## Harnett County

**Permit Number: BCOM2506-0003**

Description: **Word and Glory Church in existing building**

Life Safety Plan

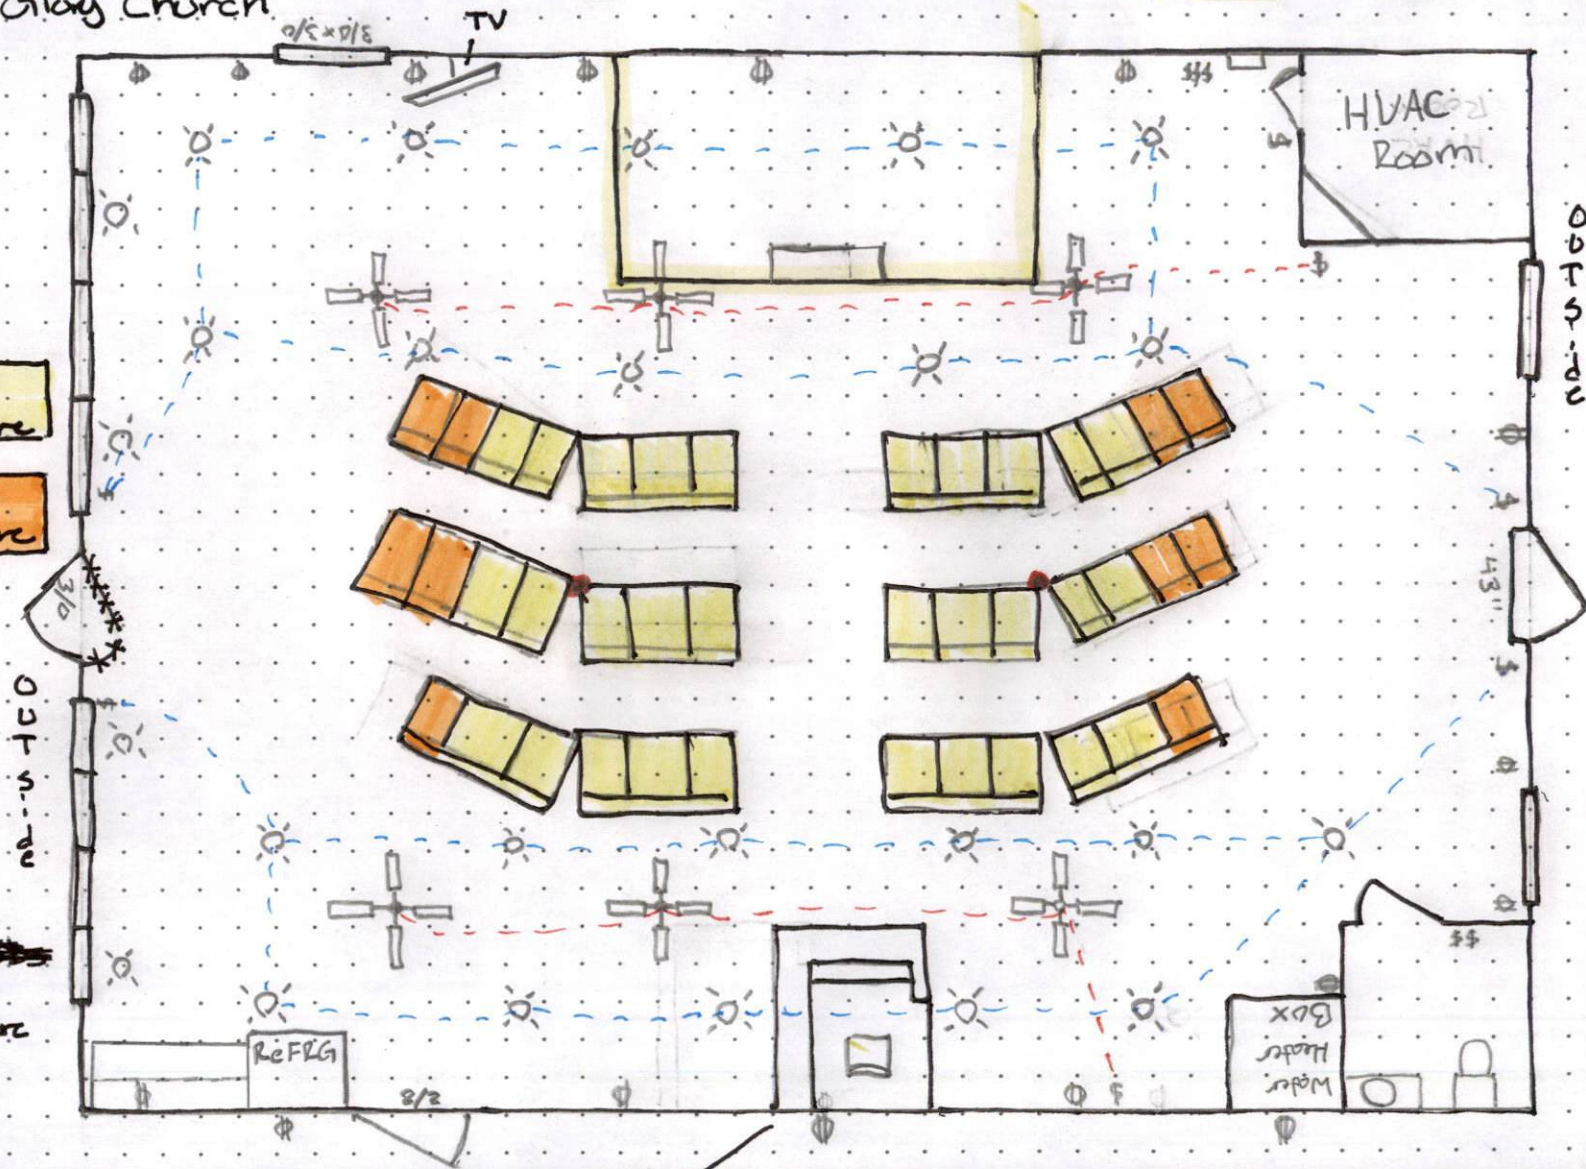
SENT DATE	RETURNED DATE	DUE DATE	TYPE	CONTACT	STATUS	REMARKS
Review Group: ALL						
7/23/2025	7/31/2025	8/6/2025	FIRE MARSHAL	Roger Sullivan	DISAPPROVED	see notes
Notes: See building inspector notes, same comments.						
10/23/2025	10/28/2025	11/6/2025	FIRE MARSHAL	Roger Sullivan	DISAPPROVED	in attachments
Notes: Same comments as the building inspector. There are three units and three addresses at this location. How are the side exits directly to the outside? Is this upfit taking the whole building? Are the walls being removed from the other tenant spaces to make one building/address?						
Review Group: AUTO						
6/10/2025	6/10/2025		COMMERCIAL INTAKE	CP Bucket	APPROVED	
Notes:						
6/10/2025	6/11/2025	6/24/2025	COMMERCIAL BUILDING REVIEW	Brad Sutton	DISAPPROVED	
Notes: 1. If drawn to scale, please provide the scale. 2. Need to know where doors either side of seating area lead to. 3. Provide all door hardware types (lever, knob, push bar etc)

6/10/2025	6/13/2025	6/25/2025	FIRE MARSHAL	Leslie Jackson	DISAPPROVED	See Notes
Notes: - Need to submit a life safety plan. - Same comments as building.

7/23/2025	7/29/2025	8/6/2025	COMMERCIAL BUILDING REVIEW	Brad Sutton	DISAPPROVED	
<p>Notes:</p> <p>All exits shown shall be directly to the exterior of the building.          All exits doors shall swing in direction of egress          Panic hardware required for calculated occupant load.</p>						
10/23/2025	10/24/2025	11/6/2025	COMMERCIAL BUILDING REVIEW	Brad Sutton	DISAPPROVED	in attachments
<p>Notes:</p> <p>There are three units and three addresses at this location. How are the side exits directly to the outside? Is this upfit taking the whole building? Are the walls being removed from the other tenant spaces to make one building/address?</p>						
10/24/2025			COMMERCIAL BUILDING REVIEW	Building Bucket		
<p>Notes:</p>
